Traffic Impact Study SAMS Academy Albuquerque, NM July 2021

HT#A10D010
received 7/22/2021

Traffic Impact Study

SAMS Academy

Figure 6: Proposed Site Plan

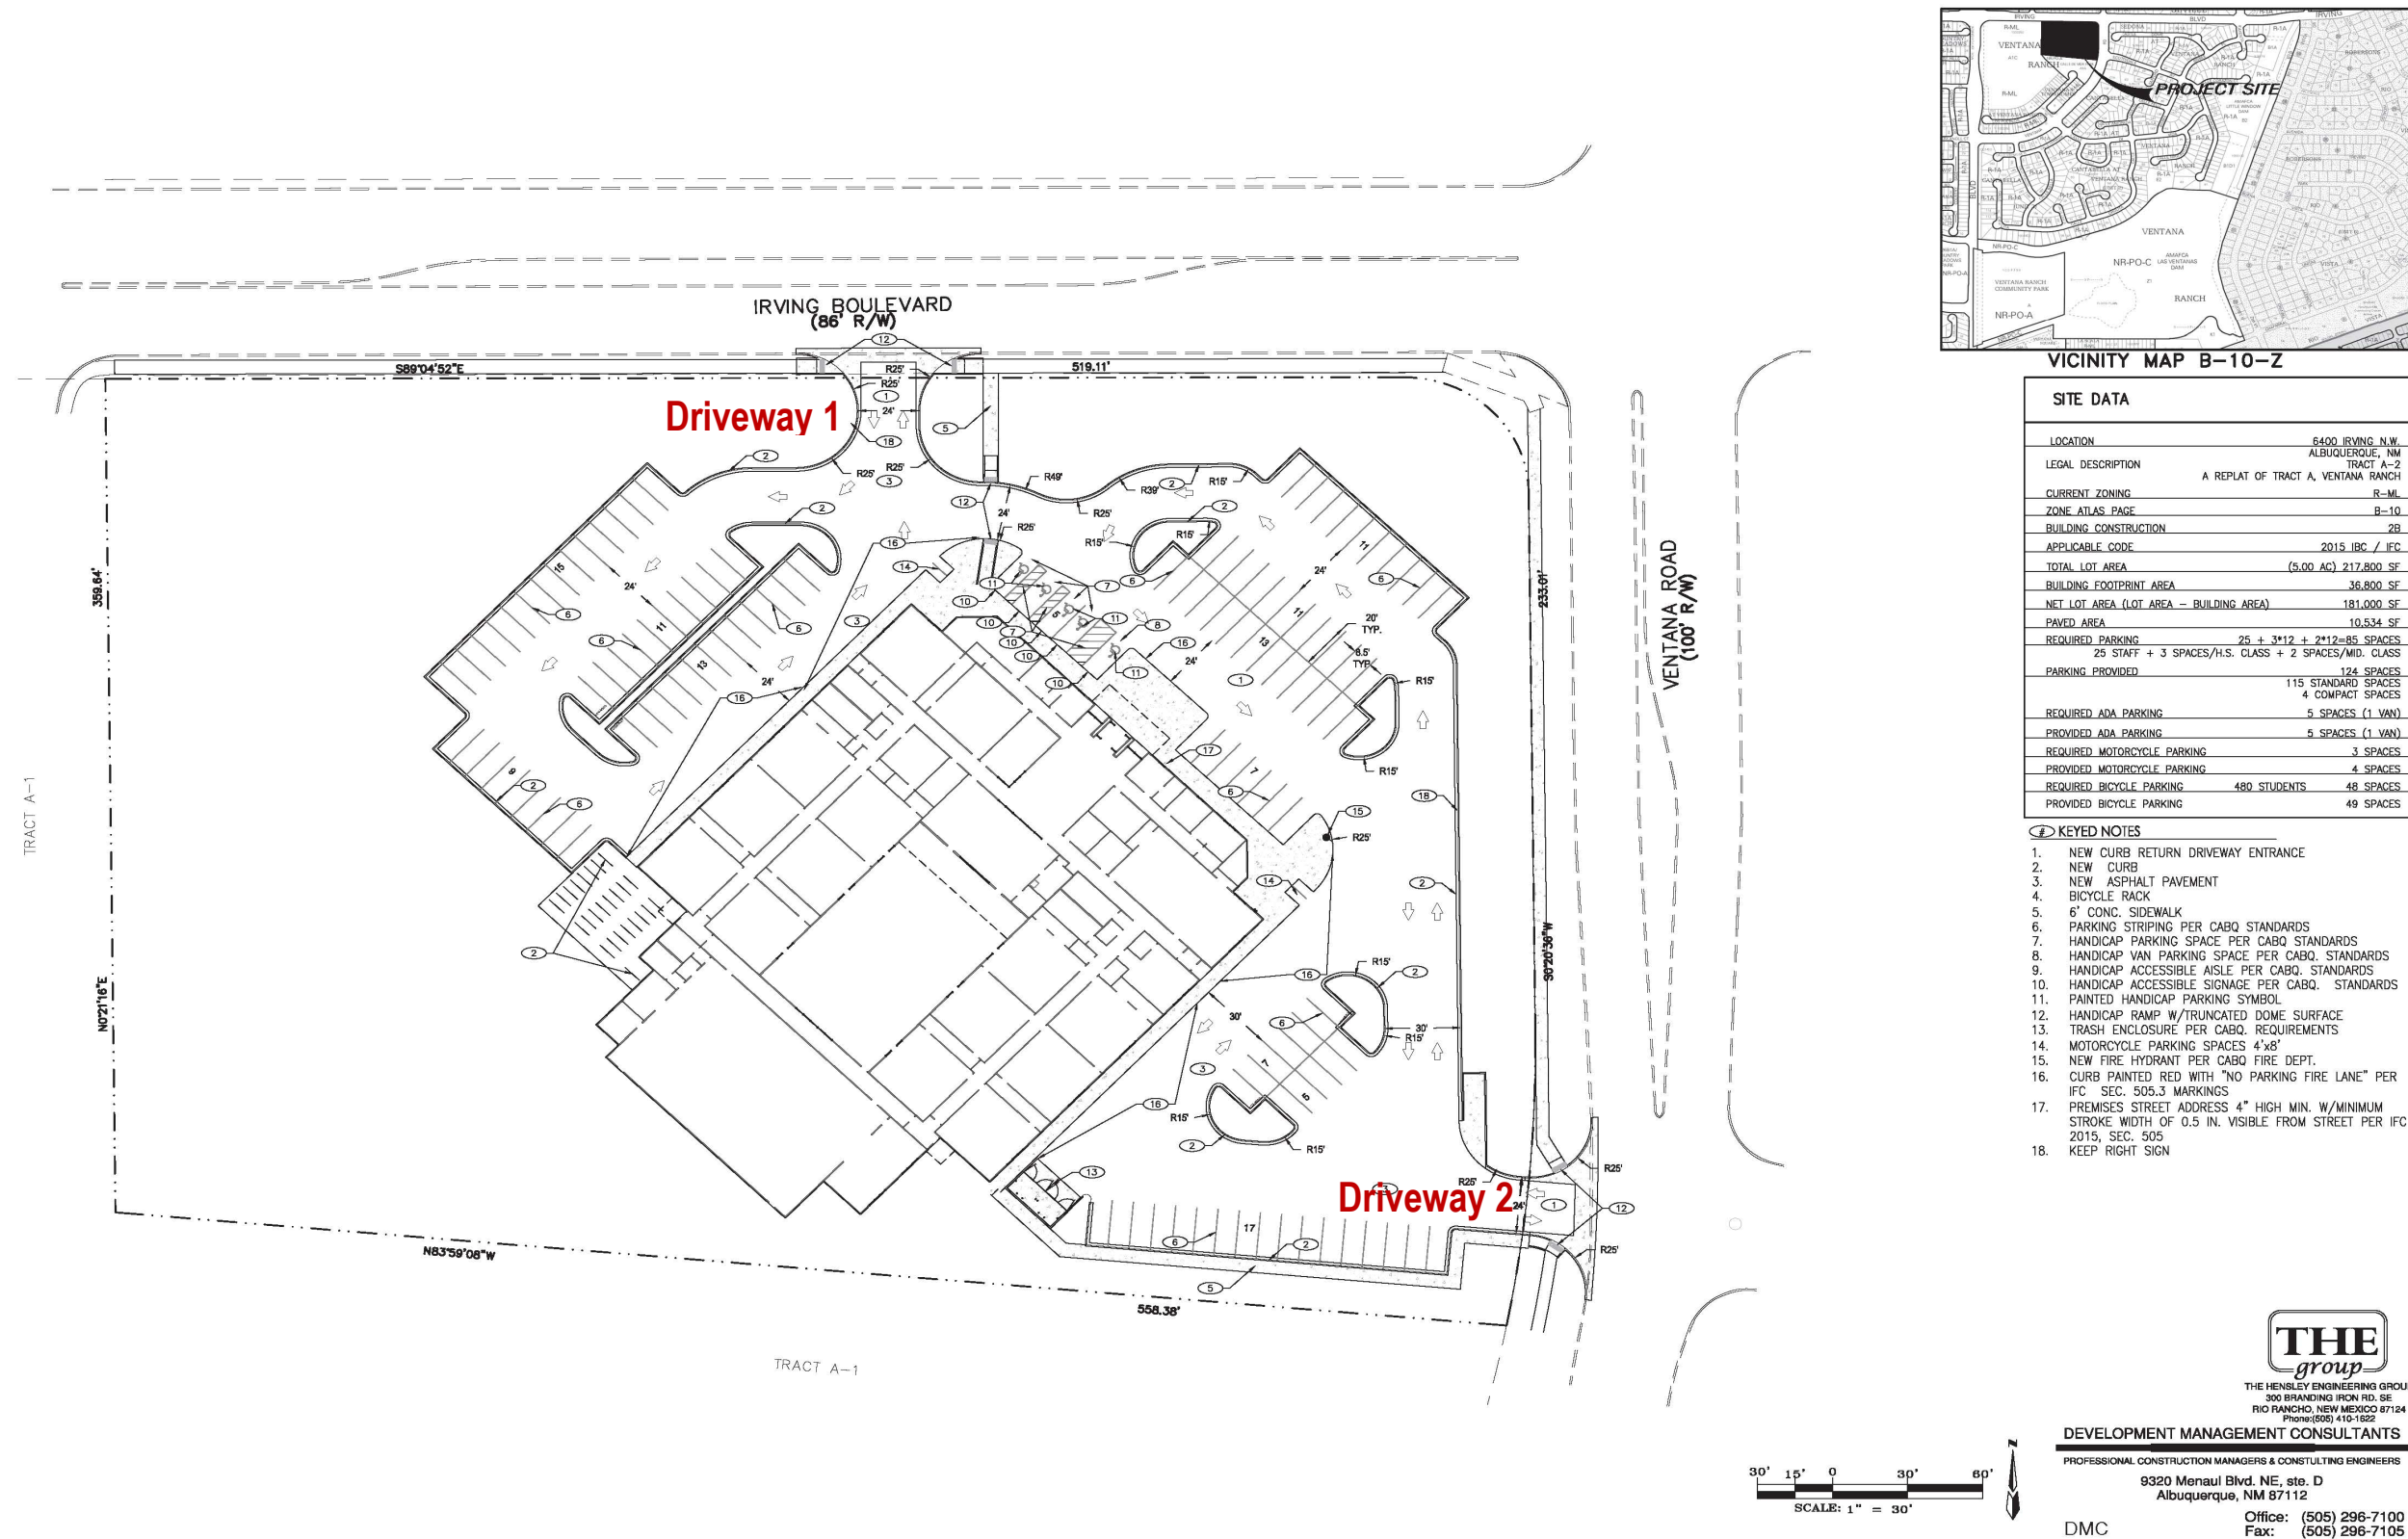
4.2.1 driveway 1 describe as a partial access

4.2.2 driveway 2 change full-service to full-access
